Our ref: RA/2021/143881/02-L01
Your ref: 2021/94208
Date: 23 March 2022

OUTLINE APPLICATION FOR RE-DEVELOPMENT OF FORMER WASTEWATER TREATMENT WORKS, INCLUDING DEMOLITION OF EXISTING STRUCTURES TO PROVIDE EMPLOYMENT USES (USE CLASSES E(G)(II); E(G)(III); B2 AND B8) – FORMER NORTH BIERLEY WASTE WATER TREATMENT WORKS, CLIFF HOLLINS LANE, OAKENSHAW, BD12 7ET

Environment Agency position

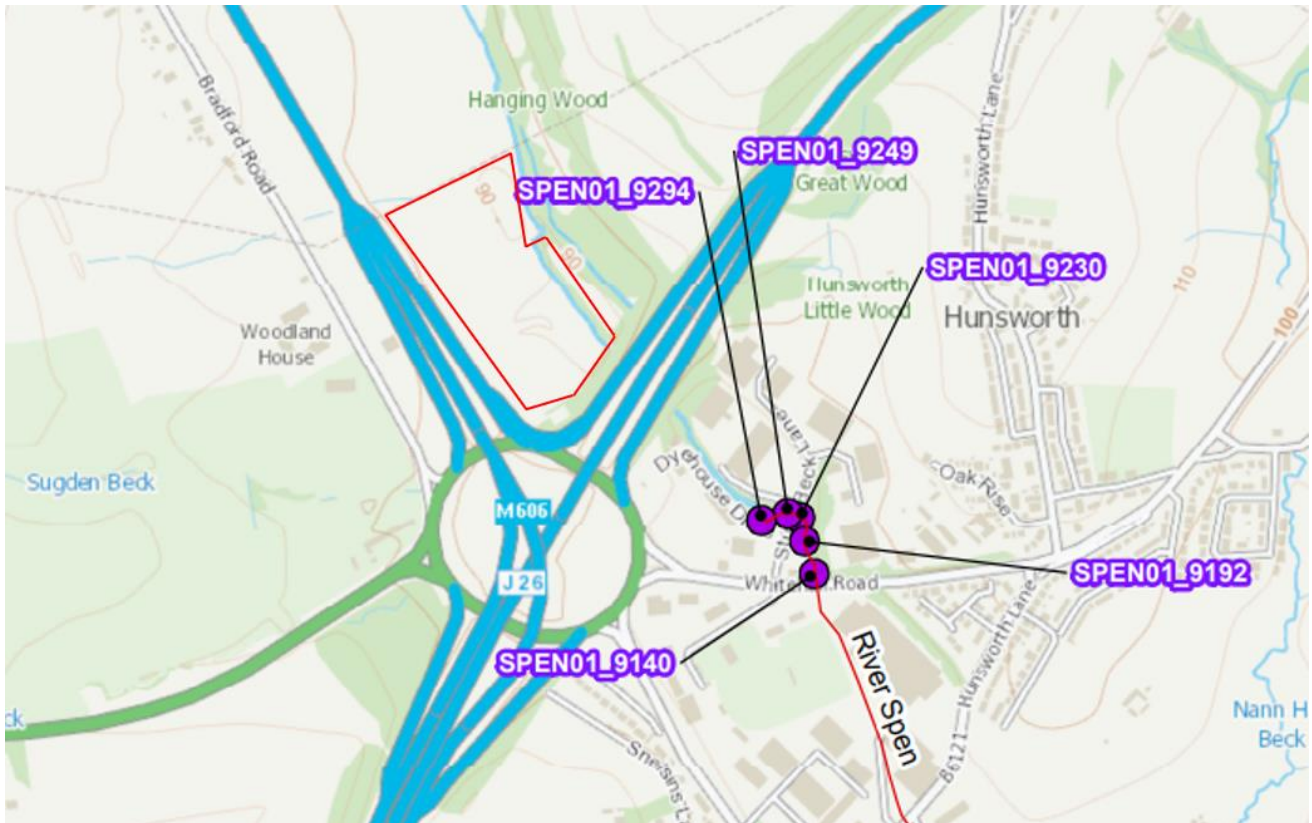
- Finished floor levels shall be set no lower than 92.0 mAOD, as detailed in sections 2 and 3 of the supplementary FRA
- No development shall take place within flood zone 3 as shown on drawing 1926-CIV-XX-XX-GA-C-00001 revision P02 dated Jan 2022
